Outer Dowsing Offshore Wind

Sabellaria spinulosa Reef Supporting Habitat Technical Note

Deadline 5

Document Reference: 22.11

Figure 1: [Habitat suitability for \*Sabellaria spinulosa\* reef within the Outer Dowsing Offshore Windfarm Export Cable Corridor \(ECC\) and Inner Dowsing, Race Bank and North Ridge Special Area of Conservation \(IDRBNR SAC\).](#)

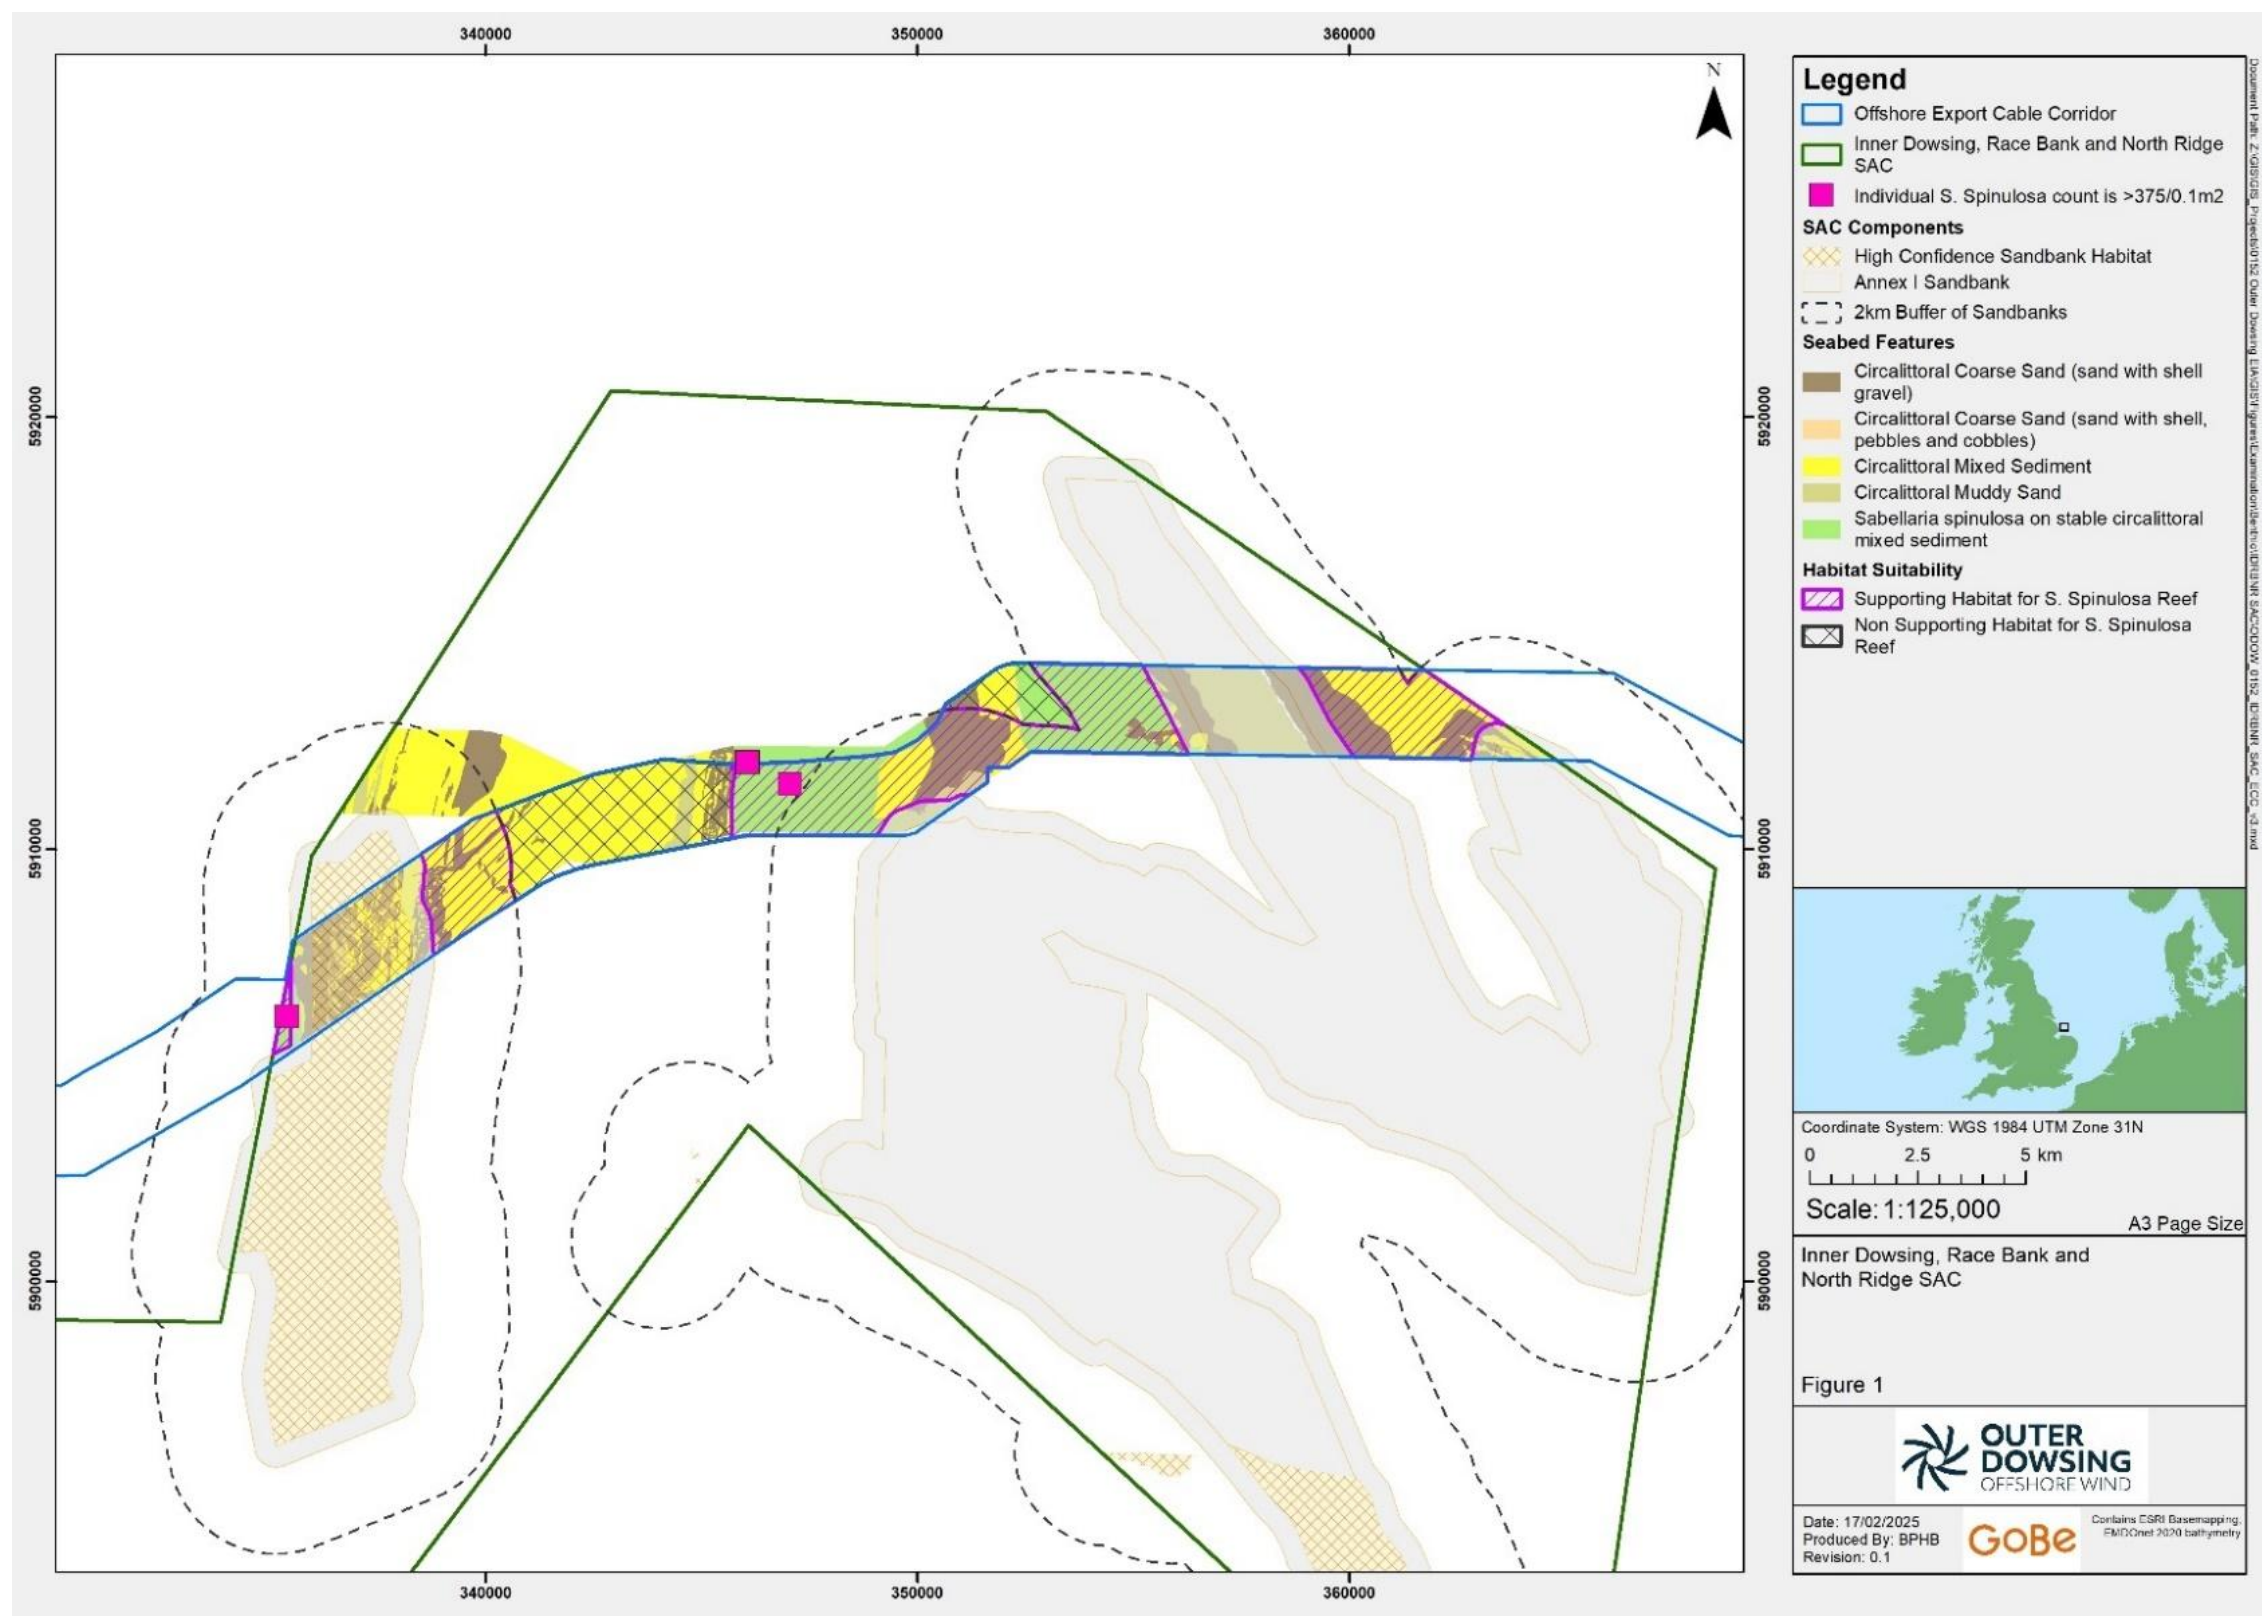
Date	Consultee and Type of Consultation	Natural England Description/Issues Raised	Response
24 th February 2025	Natural England – Discretionary Advice Service (DAS)	On behalf of the case team please find below our advice to the <i>Sabellaria spinulosa</i> reef supporting habitat Technical Note: February 2025 Document Reference: 22.11 Rev: 0.1 24.02.2025. Natural England thanks ODOV for sight of this document before submission into examination. Natural England has reviewed the document under our DAS and provides the following advice in relation to the methodology used to identify supporting habitat and proposed mitigation measures for areas of supporting habitat/processes. Methodology 1. Table 2 [Table 1.3], optional parameter 1 – It is not clear if this parameter has considered dominant direction tidal flows which would require an increase in the buffer from 2 km to 3 km. The figures in 'Chapter 7 Marine Physical Processes Figures Part 1 of 2' demonstrate that the dominant tidal flows and bedload transport across the ECC are in the NNW and SSW directions, and as such, we advise that the 2 km buffers applied should be extended to 3 km to align with the description of optional parameter 1 within the Technical Note.	The Applicant notes difficulty in interpreting 'Optional parameter 1,' specifically the phrasing: "within 2 km of sandbanks in any direction OR within 3 km in the direction of tidal stream, whichever is the greater 2." Our initial interpretation was that the worst-case area for the majority of the Offshore ECC was 'within a 2 km radius of the sandbanks'. This interpretation arose due the direction of the tidal stream (approximately NW-SE/ N-S, see Figure below [Figure 1] which presents tidal ellipses), we therefore did not anticipate that this would have a greater impact on the width of the corridor than the 2 km buffer applied around the entire sandbank. Furthermore, there was additional confusion surrounding the phrase "OR within 3 km in the direction of tidal stream," as it does not clearly state what the 3 km buffer is associated in relation to the tidal stream – we assume that this would be the northern points of the sandbanks for the current features of interest. We have mapped the tidal ellipse data (see figure below), which demonstrates that a 3 km buffer could be applied to the north of the sandbank features, specifically "in the direction of tidal stream." This would result in two small areas highlighted by the red cross hatch in the figure below

Date	Consultee and Type of Consultation	Natural England Description/Issues Raised	Response
			being included as supporting habitat. This additional area is 2.5 km ² . As illustrated in the figure, no other additional adjustments in relation to 'Optional parameter 1' are necessary.
24 th February 2025	Natural England – Discretionary Advice Service (DAS)	2. In addition, for the avoidance of doubt, Figure 1 of the report should be updated and areas of Annex I sandbank delineated as potentially supporting habitat to Annex I <i>Sabellaria spinulosa</i> reef (i.e. using the purple hash) included/differentiated.	The Applicant notes that the Annex I sandbanks are not identified as supporting habitats for <i>S. spinulosa</i> reefs, in accordance with the methodology documentation and as established in the research. These features have been addressed with specific mitigation measures in their own context.

24 th February 2025	Natural England – Discretionary Advice Service (DAS)	3. Table 2 [Table 1.3], optional parameter 2 and 4 – Natural England advises that were this parameter to be appropriately applied to the data presented in Figure 1, then all areas of the SS.SBR.PoR.SspiMx biotope (including that outside of 2 km sandbank buffer) should have been included as supporting habitat for Annex I <i>Sabellaria spinulosa</i> reef.	The Applicant notes that this area has now been included as supporting habitat for Annex I <i>Sabellaria spinulosa</i> reef as demonstrated in the Figures above, when applying the 3 km buffer to the north of the middle sandbank feature.
24 th February 2025	Natural England – Discretionary Advice Service (DAS)	4. In addition, Figure 1 does not appear to include all areas that were identified as SS.SBR.PoR.SspiMx within the <i>Offshore Export Cable Corridor Sabellaria spinulosa Reanalysis and Report Date: December 2024 Document Reference: 15.13 V2 Revision: 2.0</i> and labelled as "Figure 2. Marine habitat map at Level 4 MNCR for the Project ECC, produced using project specific data from the most recent benthic habitat surveys (ENVISION, 2024)."	The Applicant notes that there is no figure labelled "Figure 2. Marine habitat map at Level 4 MNCR for the Project ECC, produced using project specific data from the most recent benthic habitat surveys (ENVISION, 2024)" however, the Applicant has applied the SS.SBR.PoR.SspiMx biotope that has been identified across all figures within this report. Most of these areas correspond with the site-specific data [APP-155], however 5 discreet patches have been identified and included in the supporting

Date	Consultee and Type of Consultation	Natural England Description/Issues Raised	Response
			habitat for <i>S. spinulosa</i> reef area, as identified in the Figures above.
24 th February 2025	Natural England – Discretionary Advice Service (DAS)	Accordingly, we believe that the area of supporting habitat for Annex I <i>S. spinulosa</i> reef should be greater than that represented in Figure 1 of the <i>S. spinulosa</i> reef supporting habitat Technical Note.	Taking the above points into consideration the difference in supporting habitat for <i>S. spinulosa</i> reef from that previously presented is 2.64 km ² , equating to a total area of 31.23 km ² .

16. Following the assessment of supporting habitat for *S. spinulosa* reef using Natural England's approach, potential supporting habitat for *S. spinulosa* reef is present as shown in Figure 1.

19. Notwithstanding this position, the Applicant has committed to the installation of removeable cable protection on the defined areas of supporting habitat for *S. spinulosa* reef identified in Figure 1. This commitment is detailed within the Outline Scour and Cable Protection Management Plan (8.21) and in the Outline Cable Specification and Installation Plan (8.5), secured under condition 13(1)(d), Part 2, Schedule 11 of the DCO.
